**From:** Raymond Cole <[Raymond.Cole@arun.gov.uk](mailto:Raymond.Cole@arun.gov.uk)>  
**Sent:** 30 March 2021 17:29  
**To:** Planning.Responses <[Planning.Responses@arun.gov.uk](mailto:Planning.Responses@arun.gov.uk)>  
**Subject:** FW: Ford Airfield (Ref F/4/20/OUT) - Drainage Engineer Responses

**From:** Anthony McNevin [REDACTED]  
**Sent:** 30 March 2021 14:51  
**To:** Laura Gibbons <[Laura.Gibbons@arun.gov.uk](mailto:Laura.Gibbons@arun.gov.uk)>  
**Cc:** Raymond Cole <[Raymond.Cole@arun.gov.uk](mailto:Raymond.Cole@arun.gov.uk)>; Claire Potts <[Claire.Potts@arun.gov.uk](mailto:Claire.Potts@arun.gov.uk)>; Robin Shepherd [REDACTED] Jen Samuelson [REDACTED]; Robert Phelps [REDACTED]; Tarvit, John [REDACTED] Jon Regent [REDACTED] Craige Burden [REDACTED] Alan Brackley [REDACTED]  
**Subject:** Ford Airfield (Ref F/4/20/OUT) - Drainage Engineer Responses

Thank you for your latest comments regarding the surface water drainage strategy for the Ford Airfield development (Ref F/4/20/OUT) following the additional information and updated design provided in JNP Group Drainage Strategy Technical Note Ref C85228-JNP-XX-XX-RP-C-1000-P2 dated 10 February 2021.

Figure 103: SECTION A-AA - Southern park attenuation basin, terraces and woodland

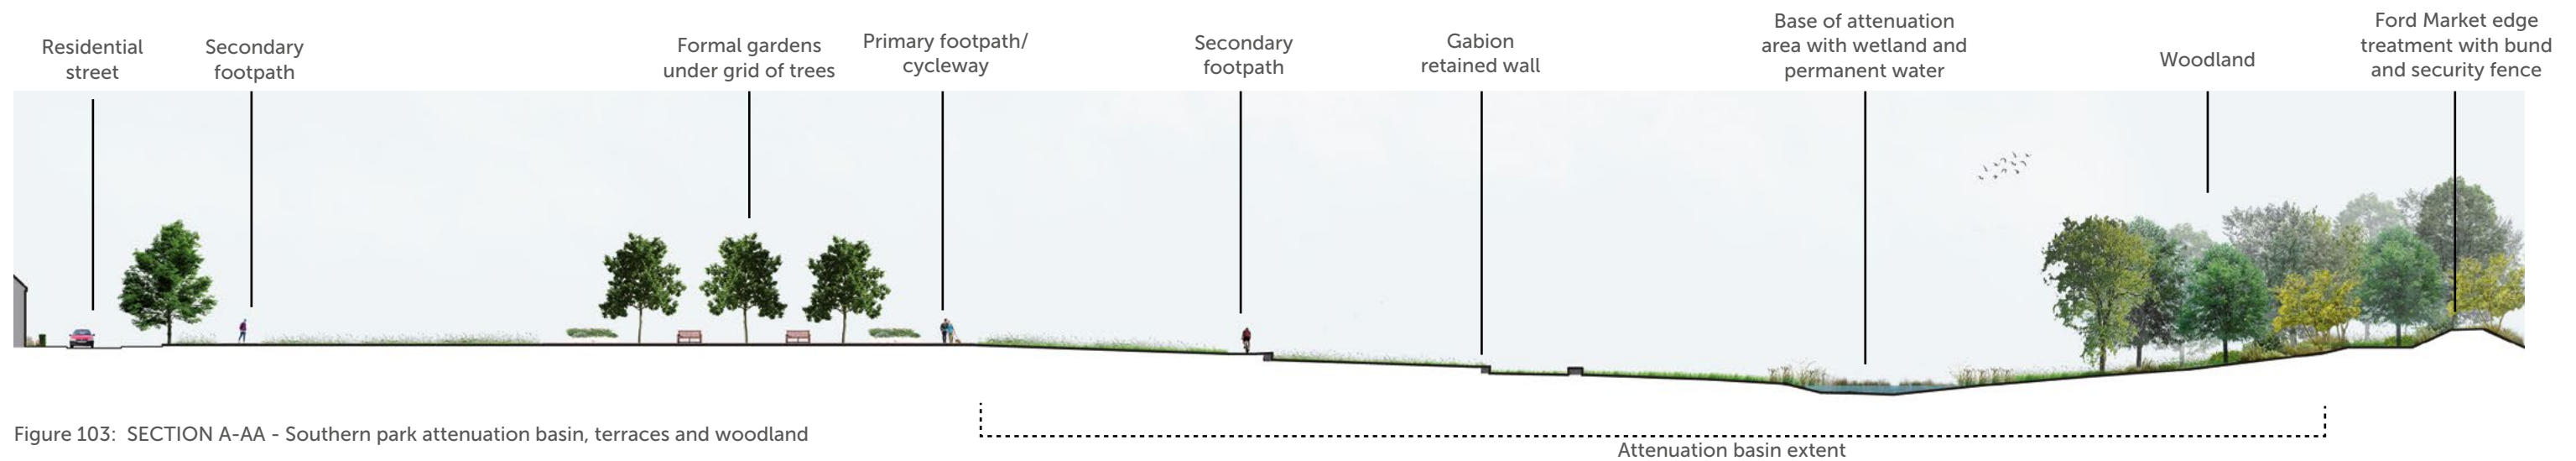
The information submitted does not address our comments from 08/04/20 or 13/01/21. For example, the masterplan document states "In the southern area some limited ground remodelling is required due to the current height of the water table and topography. Therefore, we utilised the opportunity to redirect the surface water towards the area that is affected by odour issues, making the most efficient use of this otherwise non developable land". Drainage should not be moved around to fit in to space that cannot be used for housebuilding.

The proposals for attenuation and pumping of this area of the development do not comply with adopted WSCC policy for the management of surface water, specifically policy 3- mimic natural flows and drainage flow paths. No evidence has been submitted to show why compliance with this policy requirement cannot be achieved. The natural catchment appears to indicate this area should drain toward the watercourses under Yapton Road. We do not support drainage proposals which do not follow existing catchments or look to utilise pumping.

2.6 The groundwater in the west of the site is extremely shallow. With reference to the monitoring results below it was less than 1.0m below ground level over the winter. The attenuation basin was located to Parcel 21 where groundwater is circa 1.9m below existing ground level over the winter period. This provides a more robust design for the south of the development.

2.7 The watercourse under Yapton Road / Horsemere Green Lane has a bed level of 3.03m AOD and a recorded water level of 4.00m AOD. The ground level at the western boundary of the site, nearest to the watercourse is circa 4.8m AOD. Groundwater has been recorded onsite less than 0.5m below the ground surface. Using open channels and basins in the west of the site is not feasible due to the risk of groundwater ingress. It is considered a pumping solution or significant ground raising would be required if the surface water runoff from all areas in the south of the development is directed to the Yapton Road watercourses.

Figure 111: SECTION E-EE - Northern park attenuation 'valley'

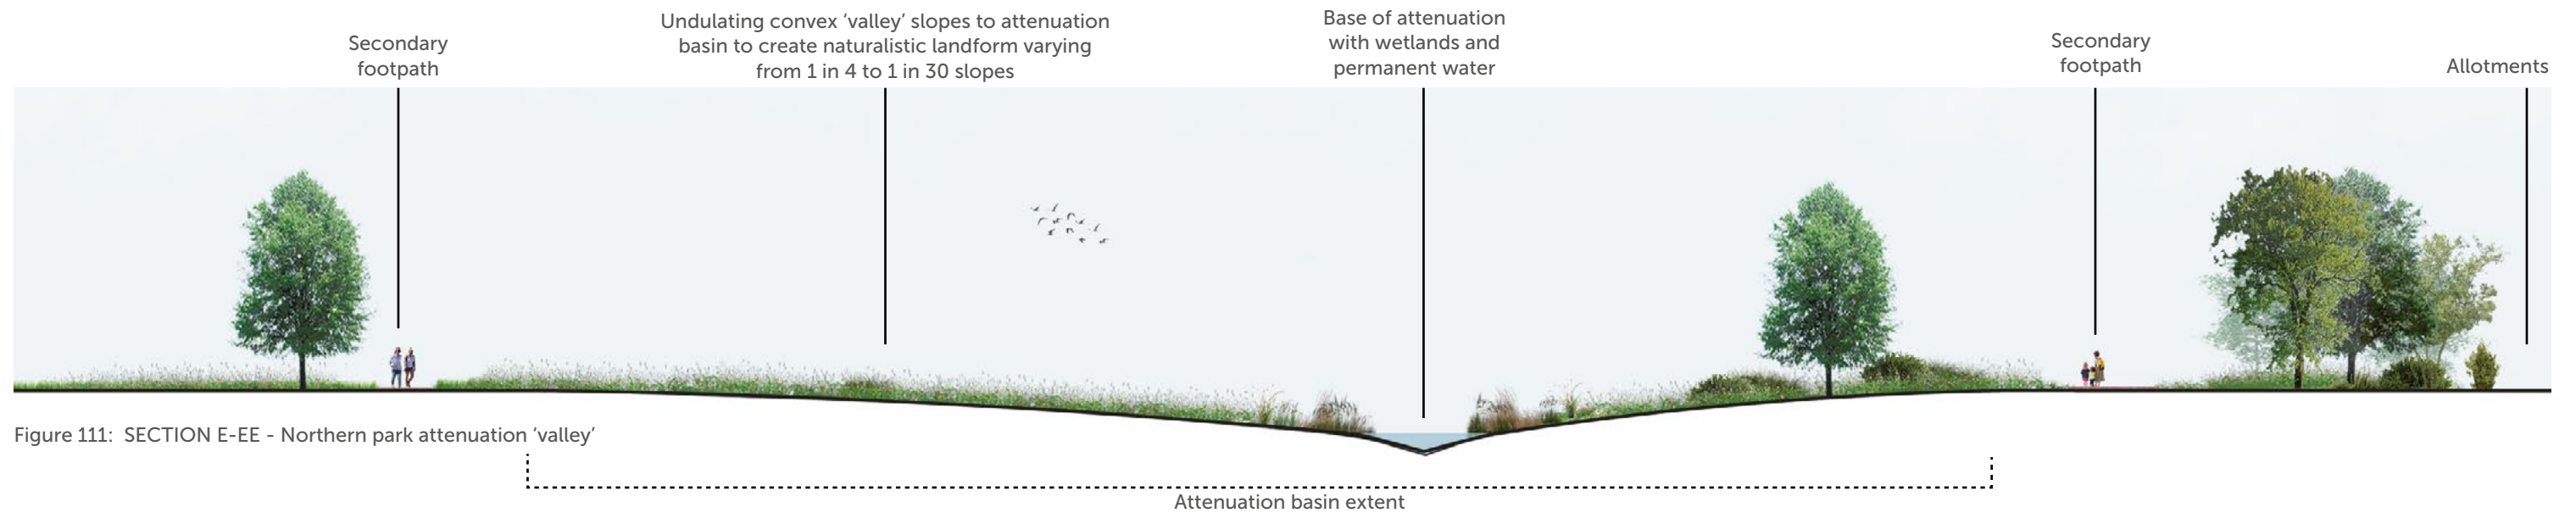
We note that the northern infiltration basin is proposed to have a base level of 2.45mAOD. There are two equidistant monitoring points from the proposed basin location, one of these recorded groundwater at 3.053m AOD. The proposed basin level therefore appears to be too low, without further evidence to the contrary. This will impact upon the upstream network, and may mean that a larger basin plan area is required. Groundwater monitoring at the location of proposed features will be required.

4.1 The groundwater monitoring of all wells across site show that groundwater flows northwards. In the north of the site the difference in water levels and the hydraulic gradient is significant. Water flows through the ground with the groundwater level deepening over short distances. The following extract from JNP Drawing C85228 D109E provided in the DSTN shows this.

4.2 Above ADC has highlighted the worst cast groundwater level in the monitoring well, to the south of the basin, is 3.050m AOD. The well to north recorded 2.257m AOD. The base of the basin is specified as 2.450m AOD. This diagram was included in Section 7.5 of the DSTN which advised “ the proposed base level of 2.450m would reduce the risk of groundwater ingress into the basin based on the worst case winter results taken during a significantly wet period”.

4.3 Due to the flow of groundwater through the underlying strata it does not appear that groundwater will pond in the basin. The groundwater levels recorded during the wettest winter period show groundwater is not level and is not static.

4.4 Section 7.8 of the DSTN confirms that basin has a 670mm freeboard to the crest of basin. The nearest plot FFL is 600mm higher than the crest of the basin. If groundwater is present in the base of the basin there is significant additional attenuation capacity.

4.5 We do not recommend the base of the basin is raised as this will increase the level of the incoming sewer network and ground levels across the north of the site. This will impact on earthworks and increase the volume of imported fill. The proposed solution and base level of the basin is the more sustainable option.
